**Ref:** SSD-77829461

**RE: OBJECTION TO SSD-77829461**

### **Ku-ring-gai Council's objection to SSD-77829461 at No. 2 – 4 Larkin Street and 1 – 5 Pockley Avenue, Roseville.**

Project Number: 122021
 Sheet Number: DA-AR-A-32-101 A
 Scale: 1:200

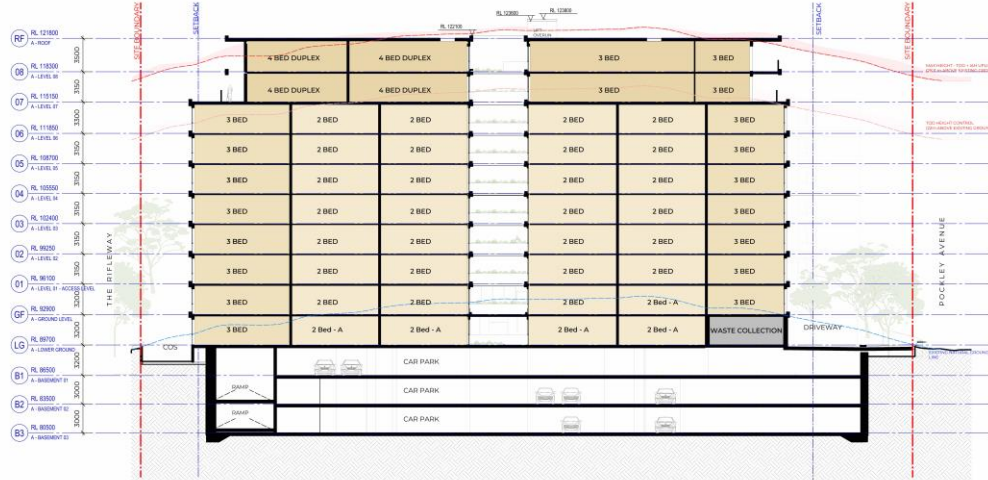
The proposal seeks a maximum building height of 30.22m, measured to top of the rooftop plant which exceeds the maximum building height control by 2.17m, equating to a variation of 7.7%.

Other building elements on the upper level of the proposed building, also exceed the maximum building height development standard as shown in Figures 1 and 2 below.

**Figure 1: Building Sections – A, Sheet No. DA-AR-A-32-101, Revision A, prepared by Woods Bagot, dated 14/04/2025.**

Project Larkin Street	Client Aqualand Prestige	Drawn by W-B WOODS BAGOT	Sheet number 122021	Sheet title Building Sections - B & C
Checked A1	Approved	Scale 25mm	Revision DA-AR-A-32-102 A	
Sheet size A1	Scale 1:200

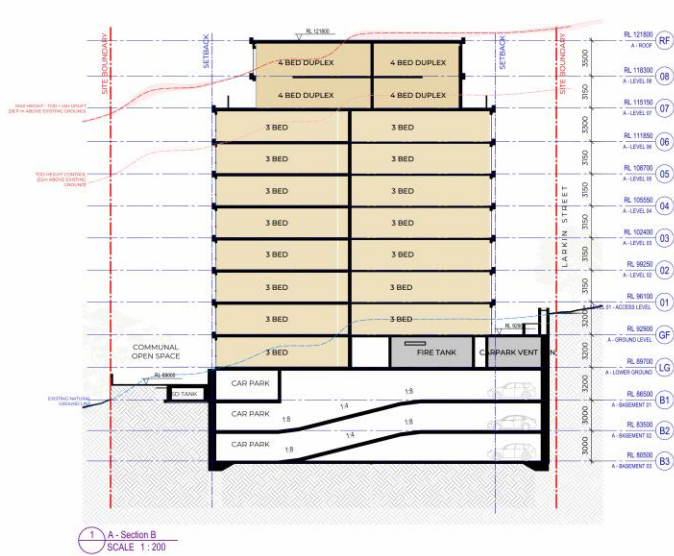
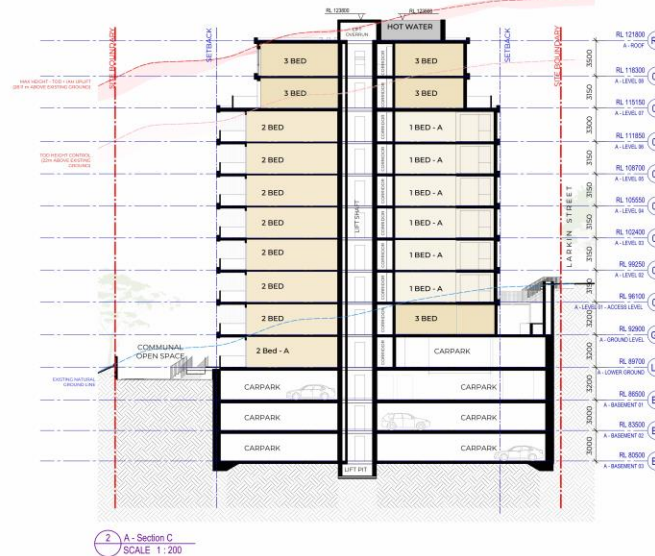
**Figure 2: Building Sections – B & C, Sheet No. DA-AR-A-32-102, Revision A, prepared by Woods Bagot, dated 14/04/2025.**
